## DECISION DELEGATED TO HEAD OF PLANNING

Application No: H16-0819-25 Applicant: MJL Property & Holdings Ltd

**Proposal:** Details of finished floor levels, Construction Method Statement, scheme of landscaping, proposed boundary treatment and materials (Conditions 3, 4, 5, 7 and 8 of H16-0061-22) - Allowed on appeal

**Location:** Land At Former Halmer Grange Spalding

Drawing
CONDITION COMPLIANCE
SITE PLAN - EXISTING
SITE PLAN - PROPOSED

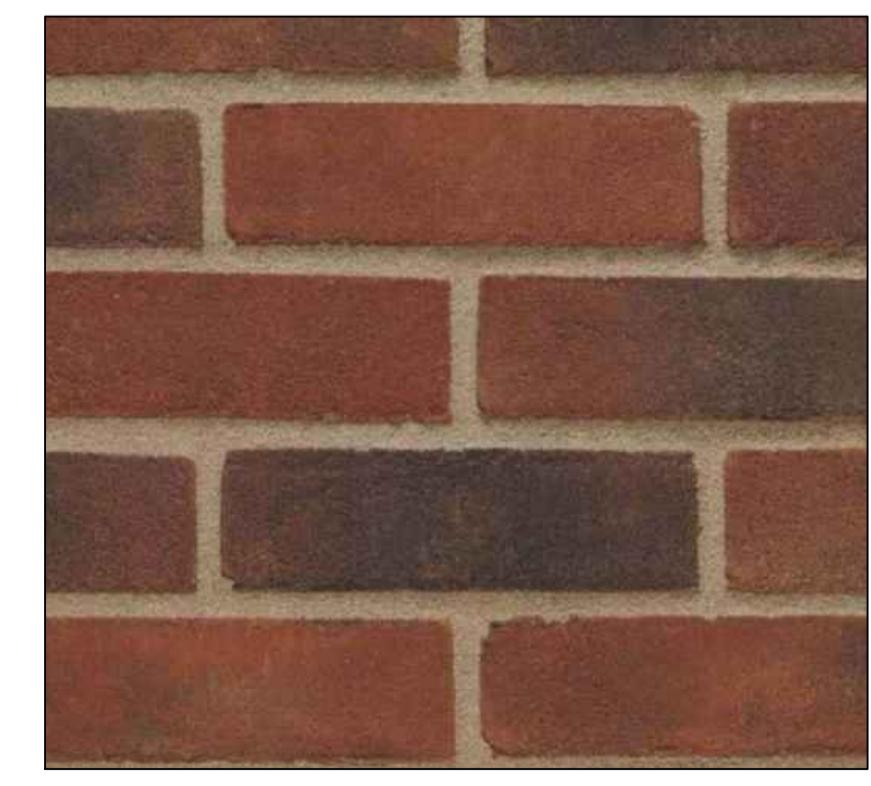
The submitted site plan (4419-25 01) shows the proposed site levels. The proposed levels within the gardens are similar to the private access road and would be similar throughout the site. As such, the site would be relatively flat throughout. The proposed floor levels of the dwellings would be 10 Above Ordnance Datum (AOD). This has been confirmed by the applicant's agent as the plans refer to the damp proof course levels as 10.15 AOD, and the ground floor levels are proposed to be 150mm lower than this. The submitted plan sets out that the first floor level will be 12.75 AOD. This would enable the development to also accord with condition 10, which requires habitable floors to be a minimum of 2m above the ground level. As such, condition 3 can be discharged.

The submitted site plan (4419-25 01) shows that the plots will feature grassed garden areas with some planting including various trees along the rear boundaries of the plot gardens and along the northern edge of the site. A hedgerow is proposed in front of the dwellings behind post and rail fencing that is proposed to be no taller than 1m in height. The submitted landscaping details are considered to be acceptable as there would be an appropriate mix of soft and hard landscaping. As such, condition 5 can be discharged.

The submitted site plan (4419-25 01) shows the existing and proposed boundary treatments. The existing 1.8m high close boarded fence along the northern boundary of the site is proposed to be retained. A similar 1.8m close boarded fence is proposed around the side and rear boundaries of the two plots. This is considered to be acceptable. Post and rail fencing is proposed at the front of the plots, in front of mixed hedgerows. The fencing would be no taller than 1m. Post and rail fencing is more typically seen in rural areas, however, it is considered that the visual impact of this fencing would be acceptable given that the fencing would be no taller than 1m.
